# CITY OF ALBUQUERQUE

March 20, 2023

RE: **Lot 28 Block 8 Volcano Cliffs Unit 5 SAD 227**  
**6208 Marigold Ct. NW**  
**Grading and Drainage Plan**  
**Engineers Stamp Date: 9/20/2021 (E10D111)**  
**Pad Certification Date: 5/13/2022**  
**CO Certification Date: 3/14/2023**

ENGINEER'S SEAL 9/20/21 DAVID SOULE P.E. #14522	6208 MARIGOLD	DRAWN BY: WCVJ DATE: 9-17-21 210210085-LAYOUT-9-18-21
	GRADING AND DRAINAGE PLAN	SHEET #
	 Rio Grande Engineering 1606 CENTRAL AVENUE SE SUITE 201 ALBUQUERQUE, NM 87106 (505) 872-0999	JOB # 210210085

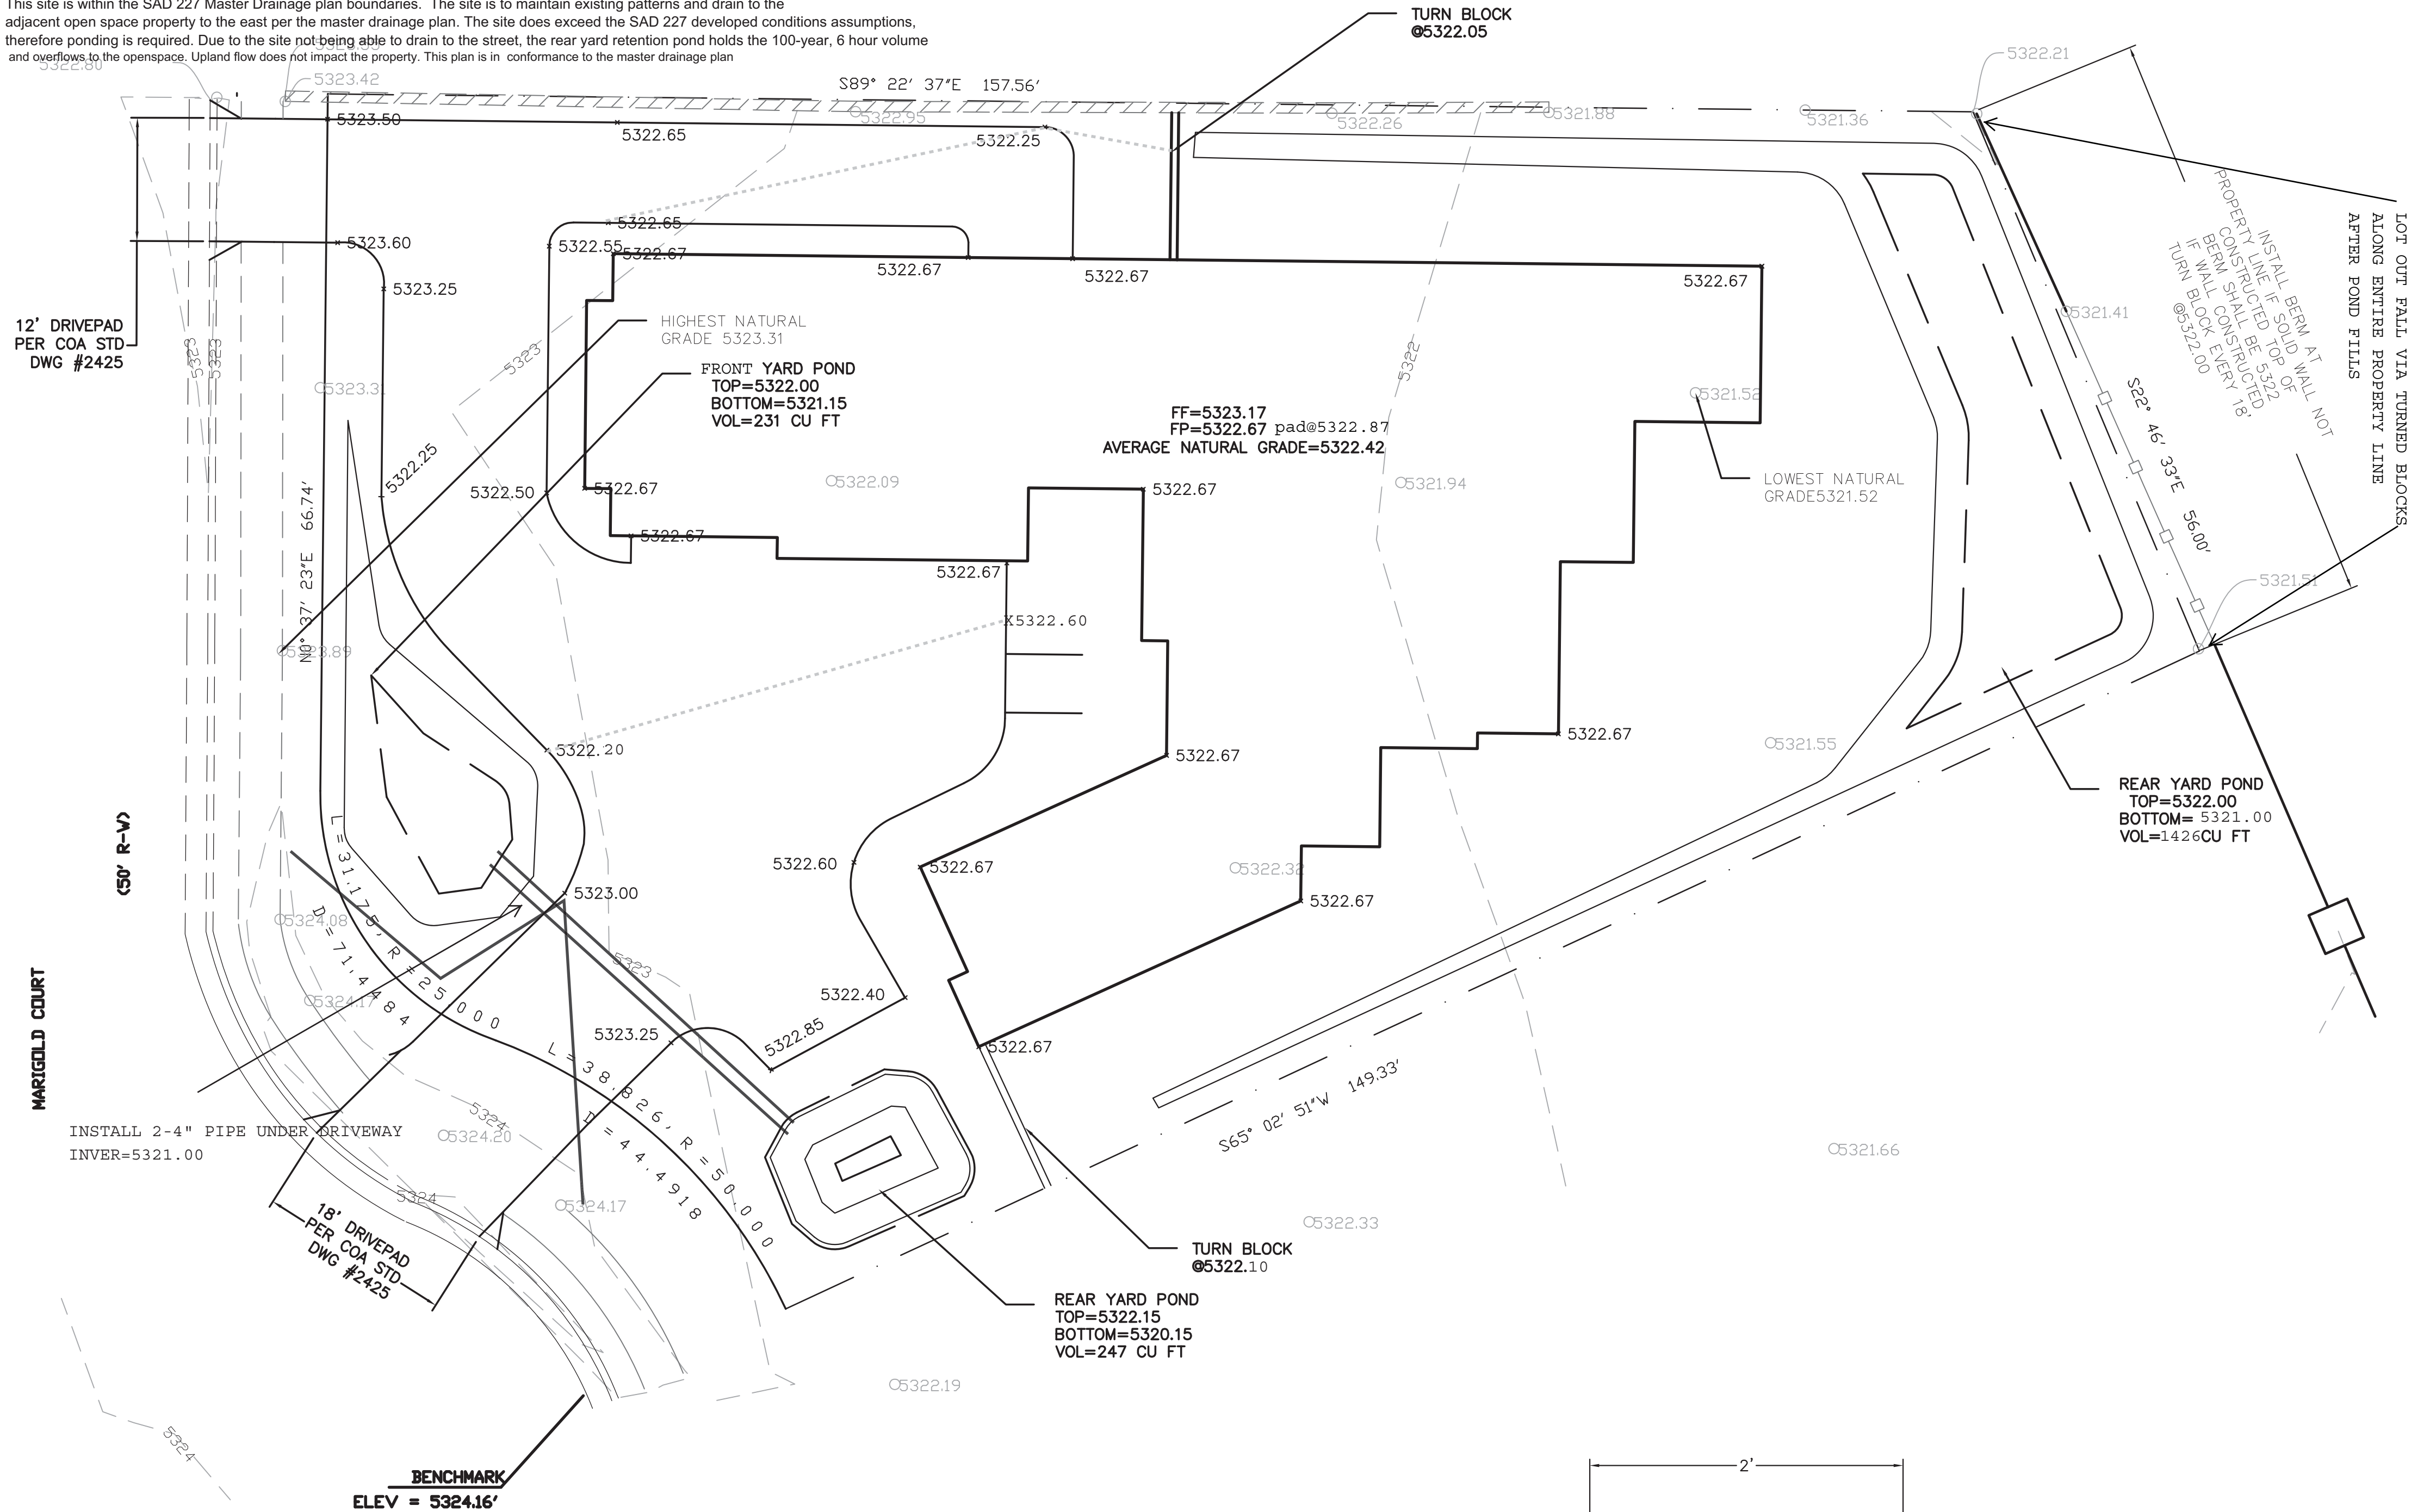
- The port-a-potty needs to be removed.
- Ponds must be filled with some type of gravel.
- Concrete drive pad must be in place.
